Application Ref:	3/2025/0518	 Ribble Valley Borough Council www.ribblevalley.gov.uk
Date Inspected:	06/03/25	
Officer:	KH	
DELEGATED ITEM FILE REPORT:		REFUSAL

Development Description:	Proposed first floor extensions and alterations.
Site Address/Location:	The Bungalow, Simonstone Lane, Simonstone BB12 7NU

A3.4

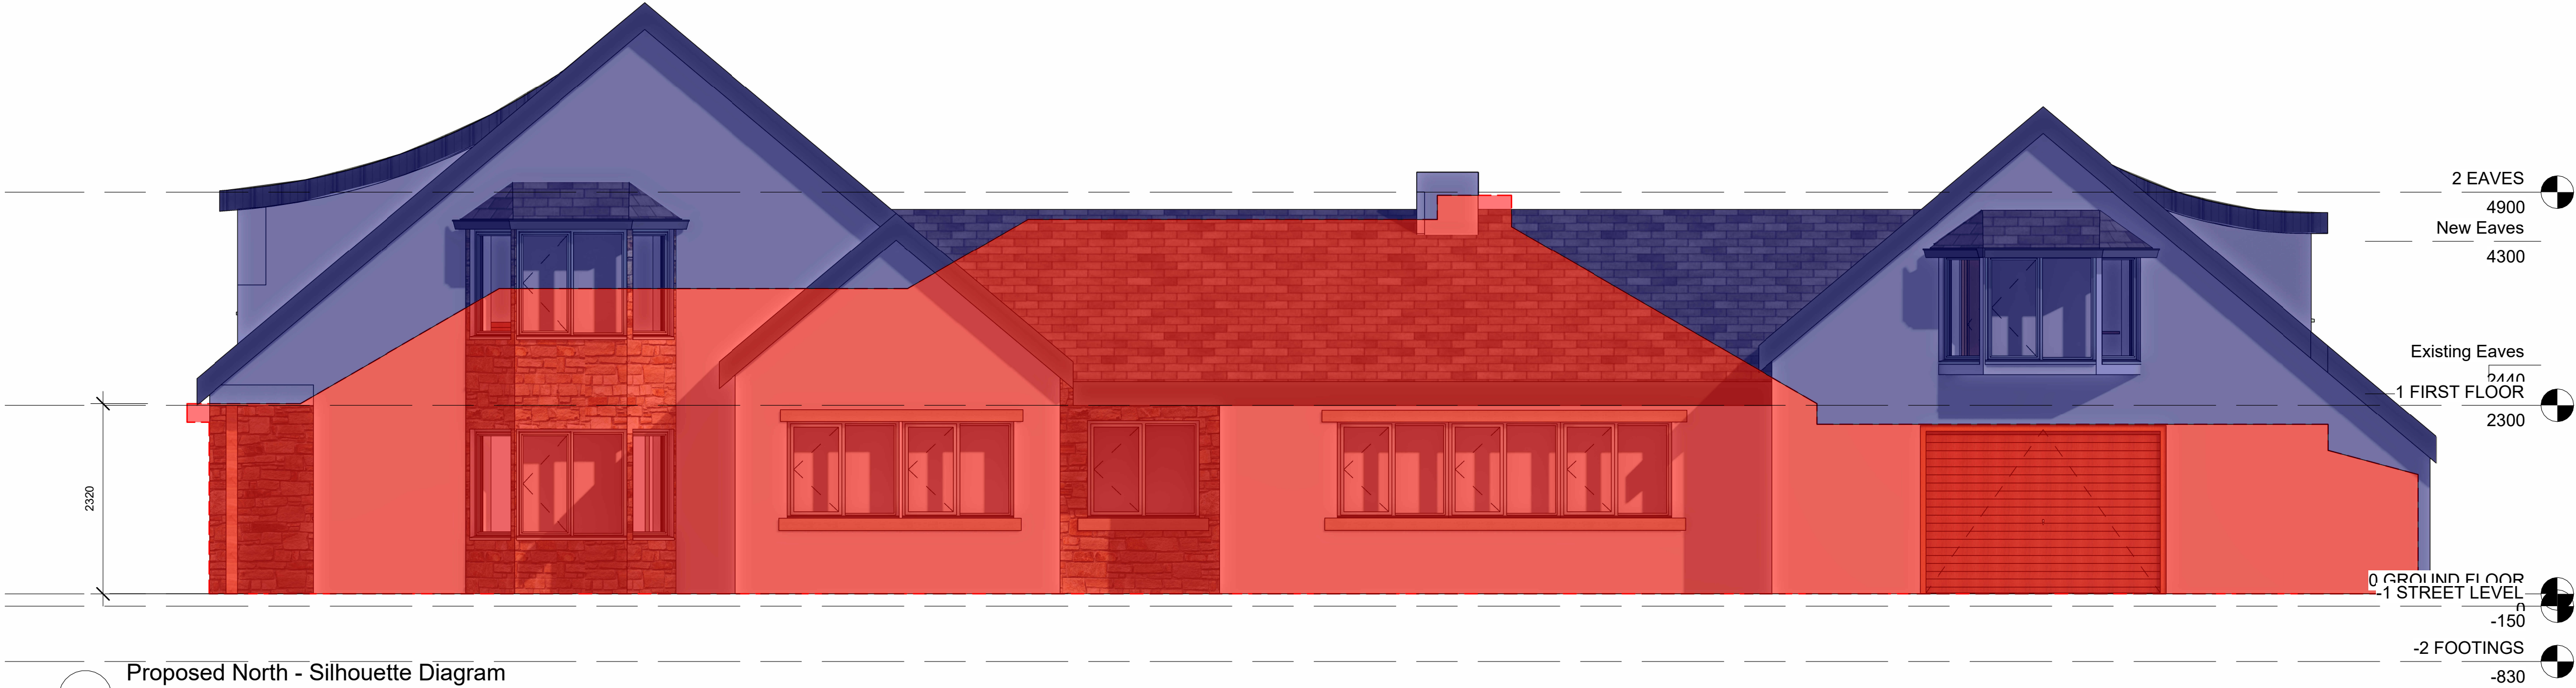
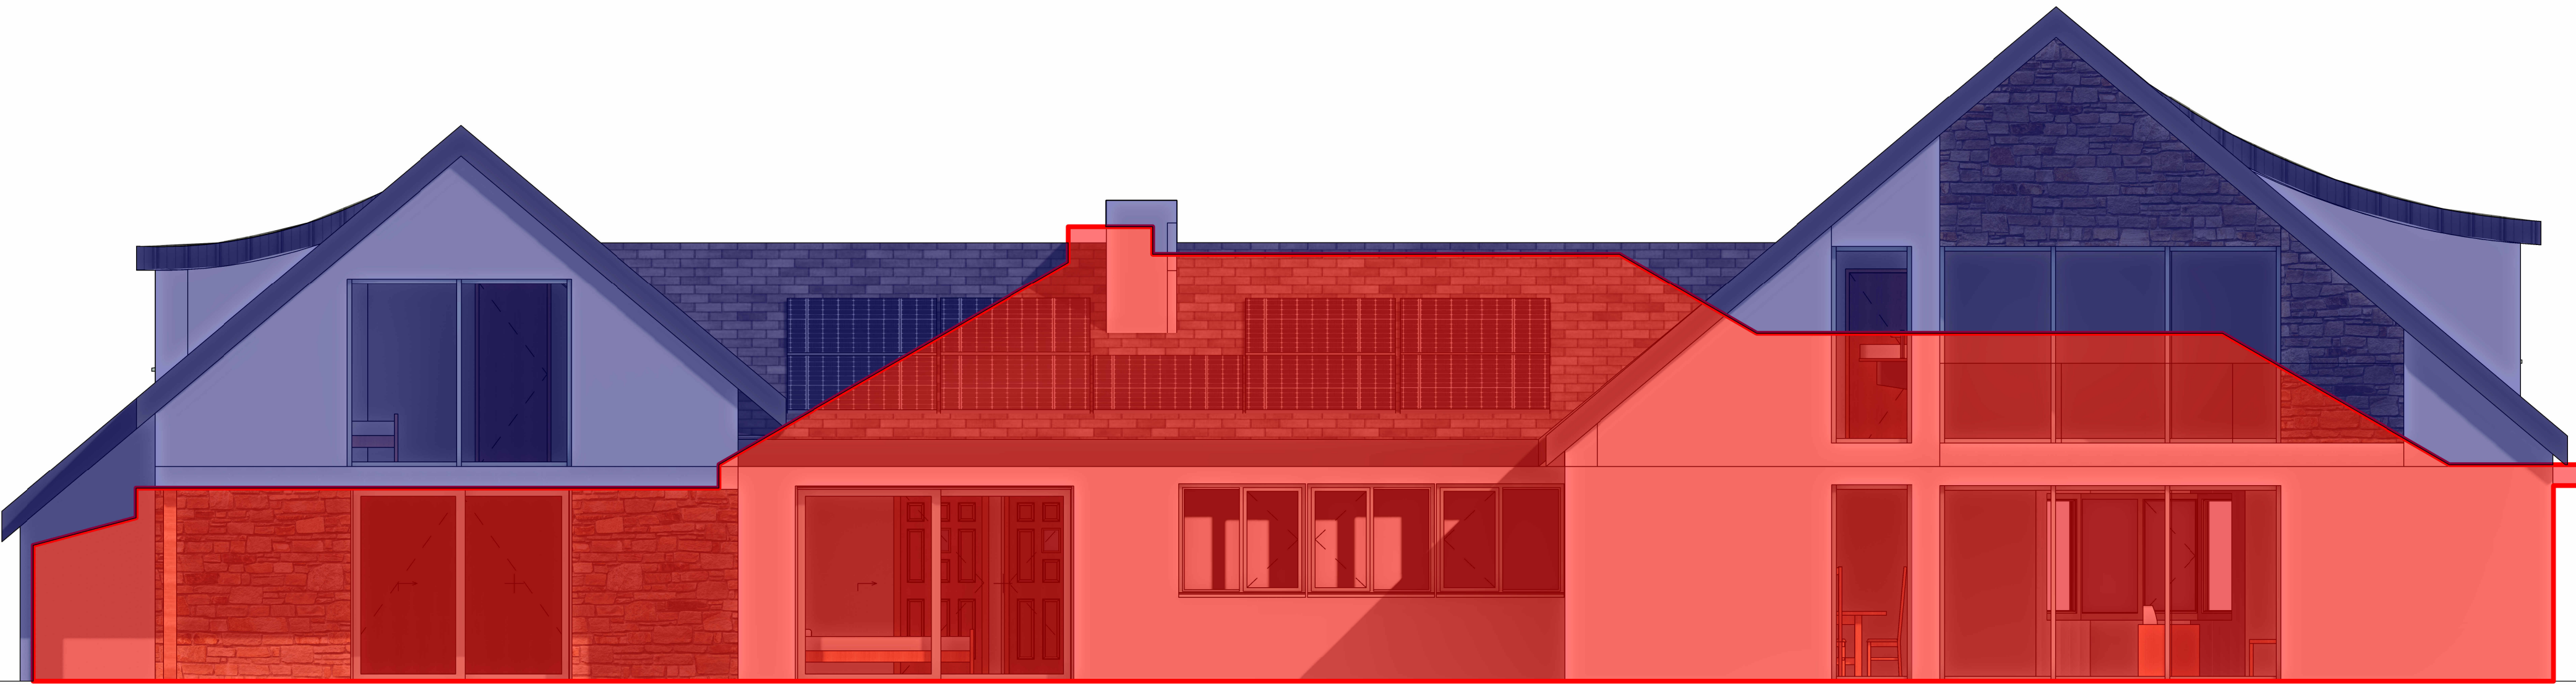
The existing property as built had an overall volume of around 300 cubic metres this property was then extended to around 611 cubic metres. This means that the existing house has already been increased by over 100% volume increase. This proposal would result in a further increase of 272 cubic metres which would result in a further increase of 45% resulting in a total increase of 883 cubic metres (194%) which cannot be considered to be small scale or proportionate to the original building.

The proposal would result in a first-floor roof lift which would increase the overall height of the original bungalow as well as both side extensions resulting in a much larger scale building than originally construction in both footprint and height. The resulting structure would be out of keeping with in terms of size, scale and massing in this location to the detriment of the rural character of the area.

Taking account of the above, it is considered that the extension, by virtue of its scale, design and massing, would result in large, unsympathetic and incongruous addition that would dominate the original dwelling and result in harm to the visual amenities of the area and the aims and objectives of Policy DMG1 and DMH5 of the Ribble Valley Core Strategy.

A2.2

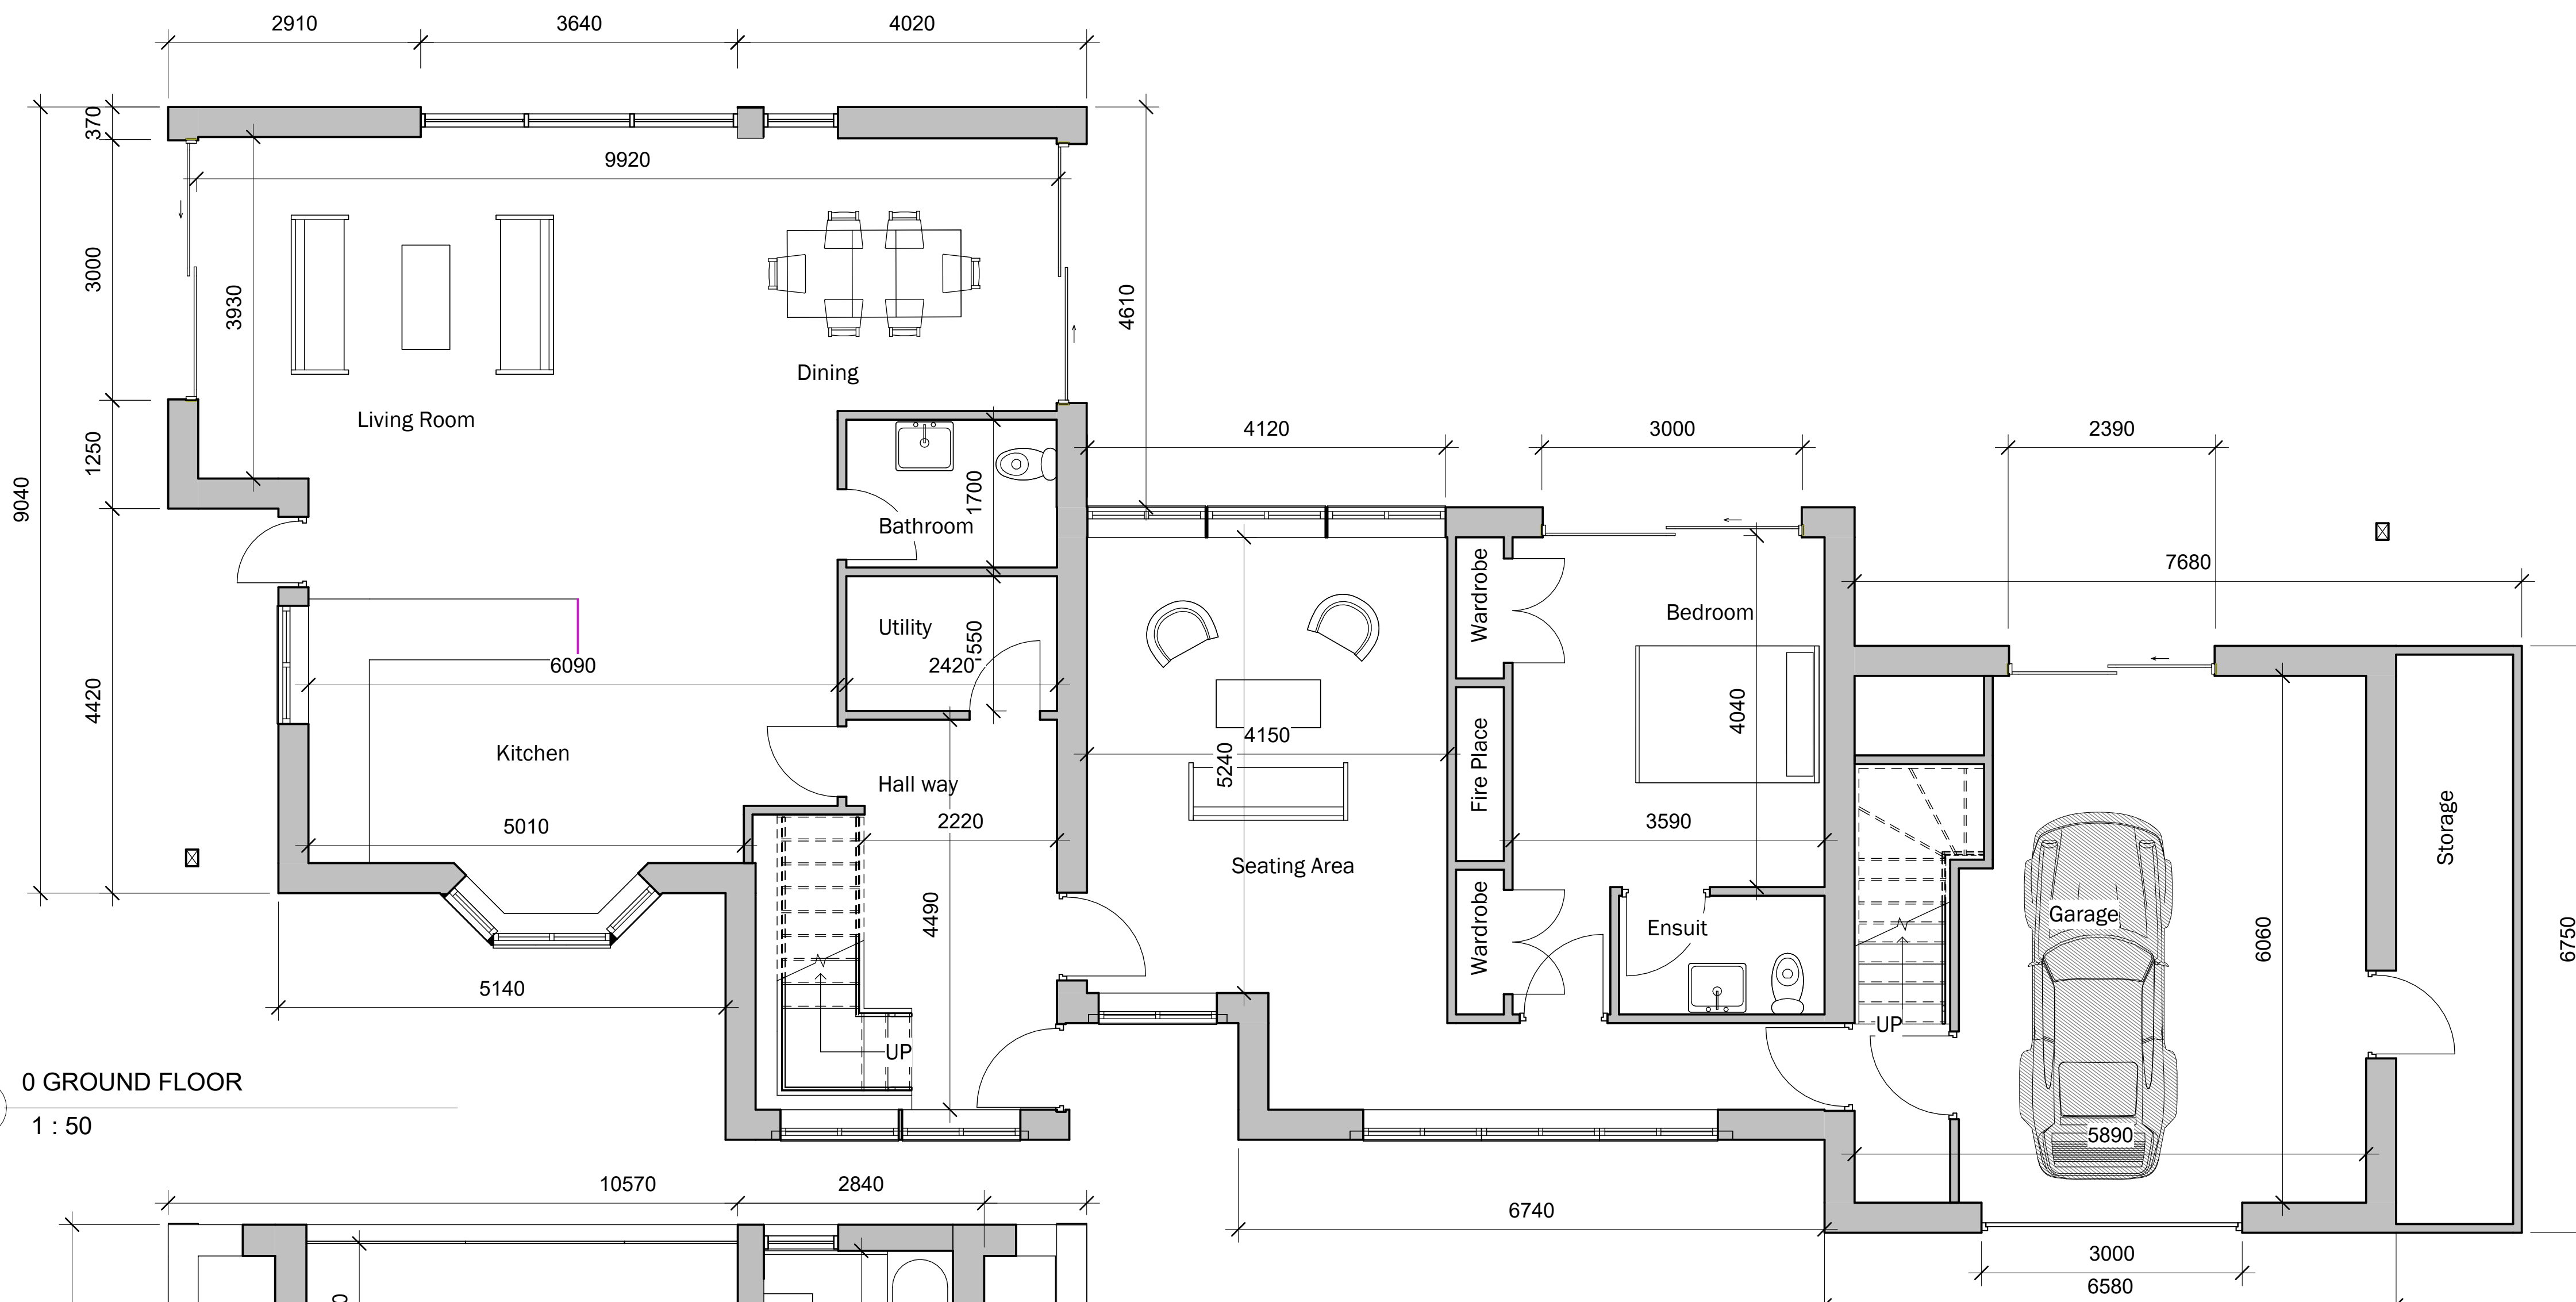
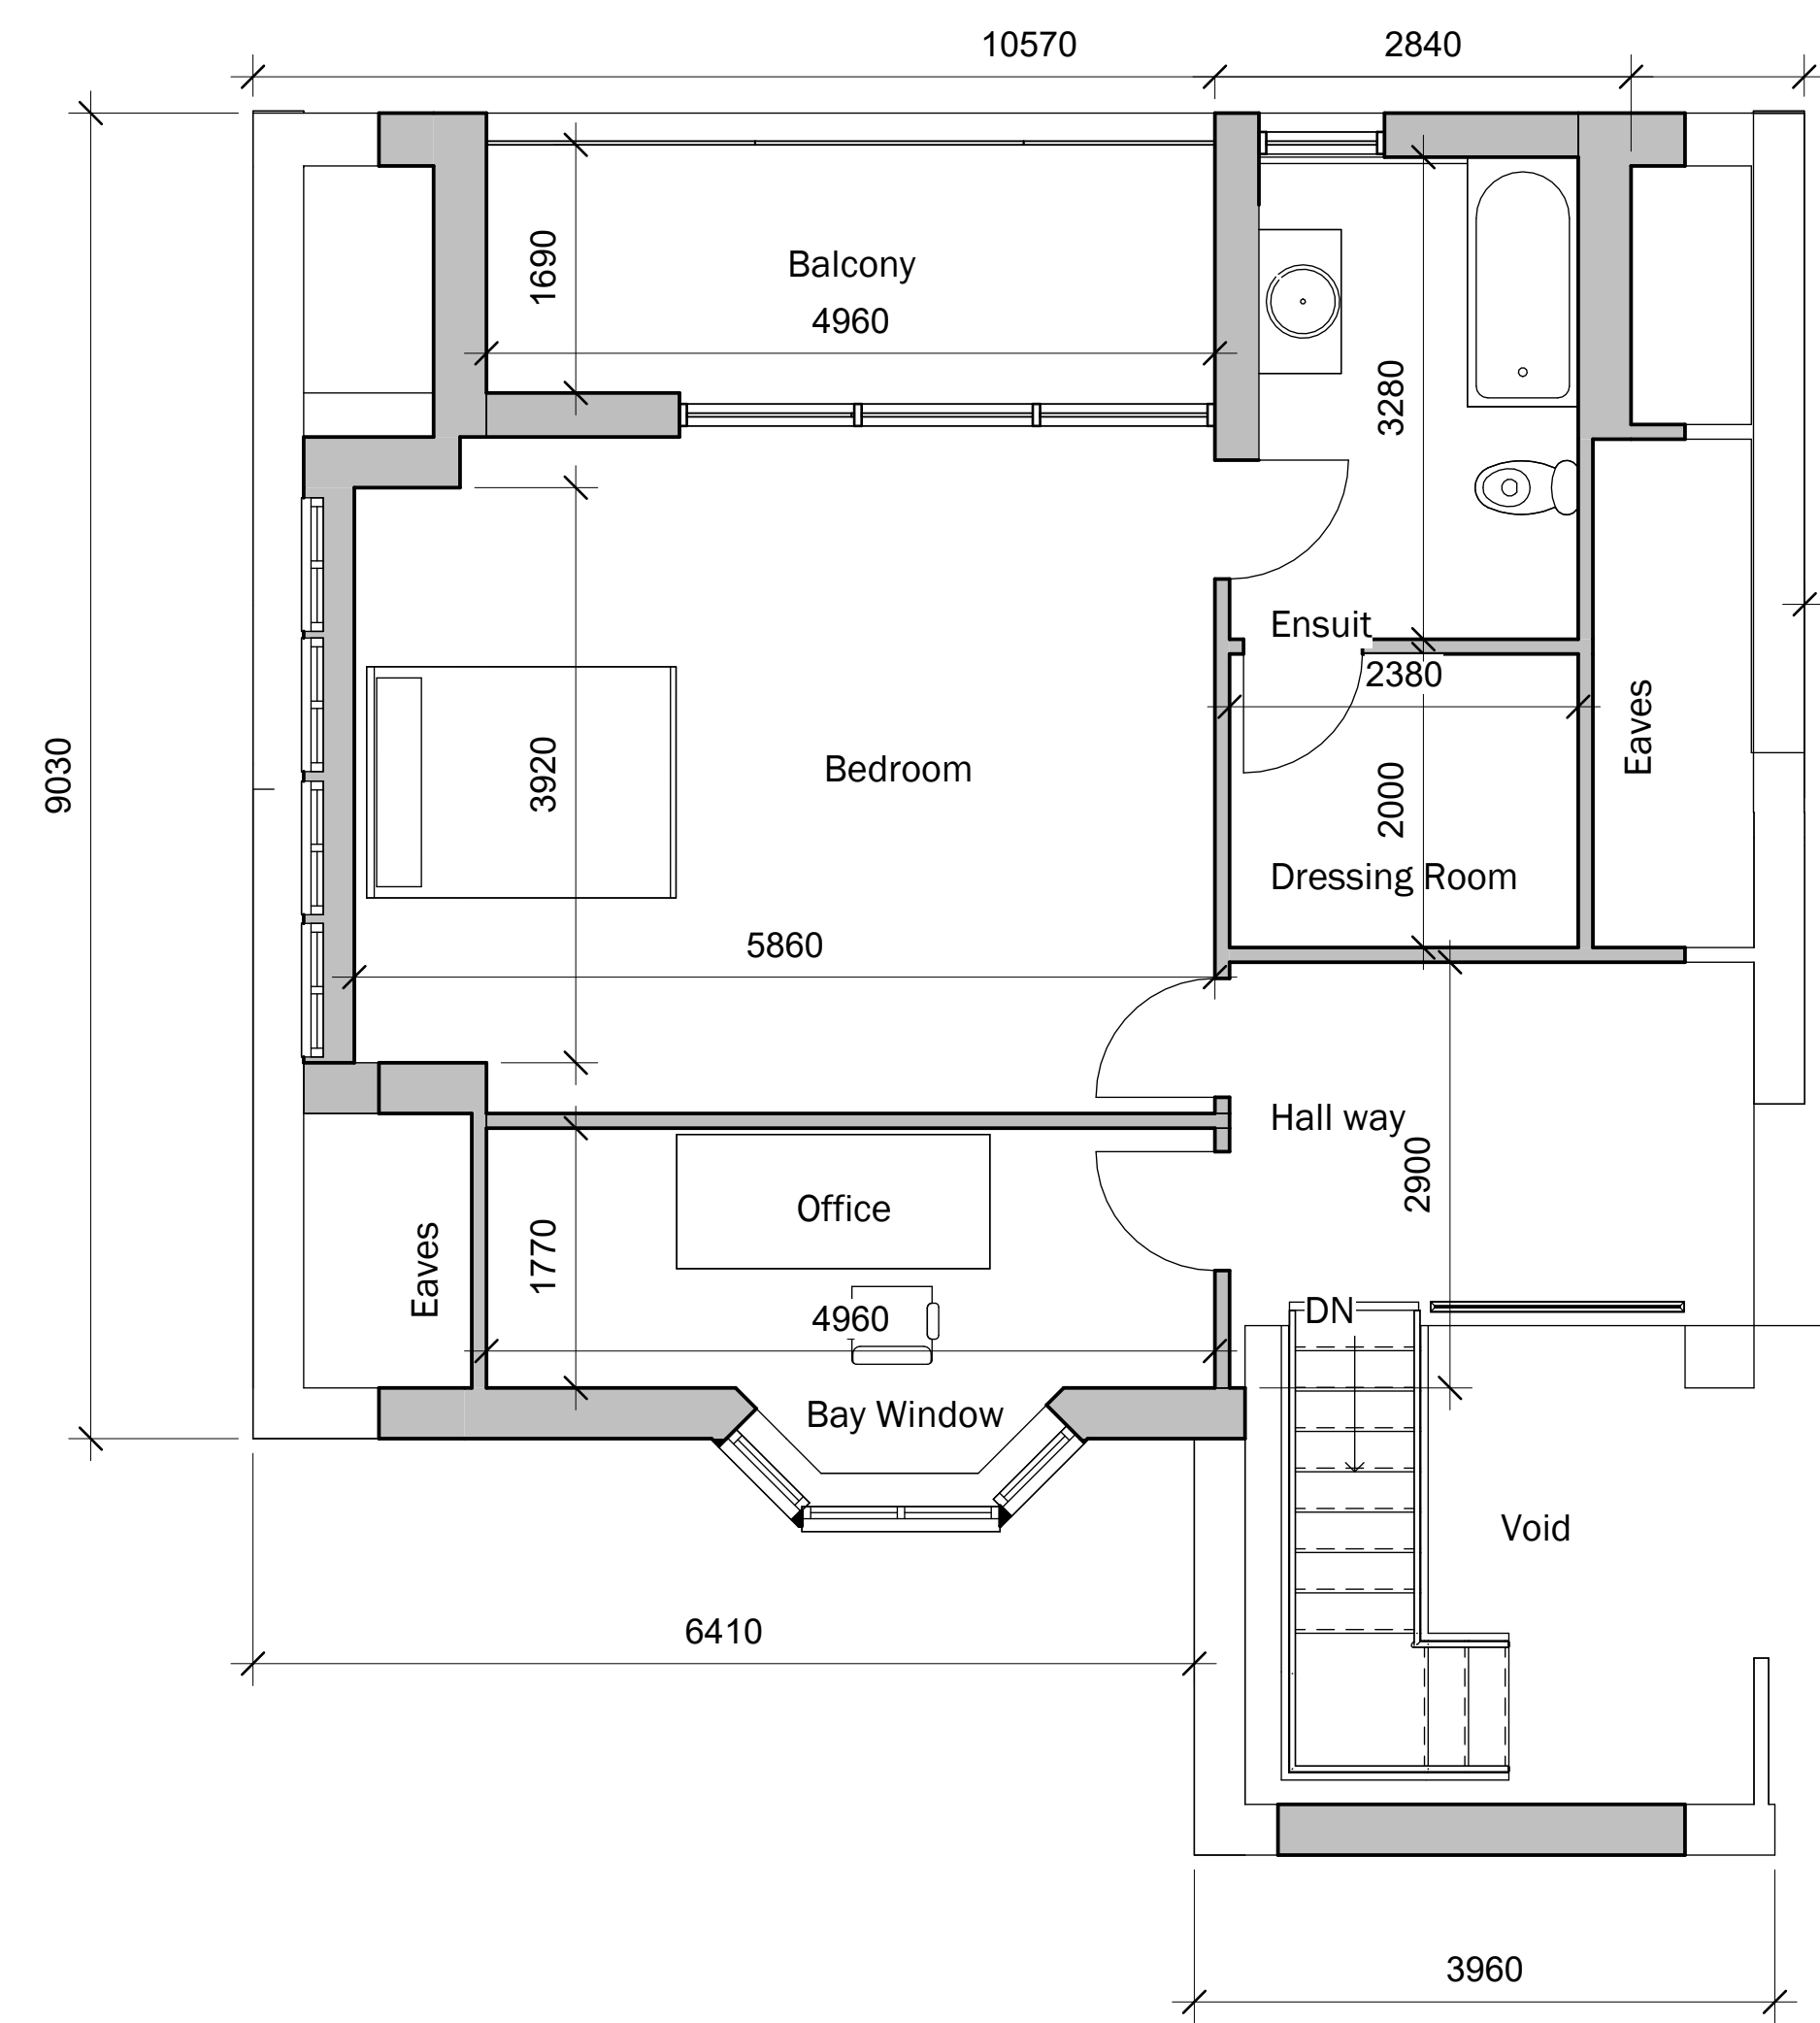
The first-floor would consist of three elements measuring approximately 9m x 10.5m, 9m x 8.5m and 8.3m x 7.6m with an overall height of 7.36m (eaves height of 2.45m) constructed with a slate roof and will form a bedroom, dressing room, ensuite bathroom, balcony and office space to the western end and an ensuite bedroom to the eastern side of the newly formed roof space with a central void area.

First floor bay windows are proposed as well as solar panels to the southern roofslope.
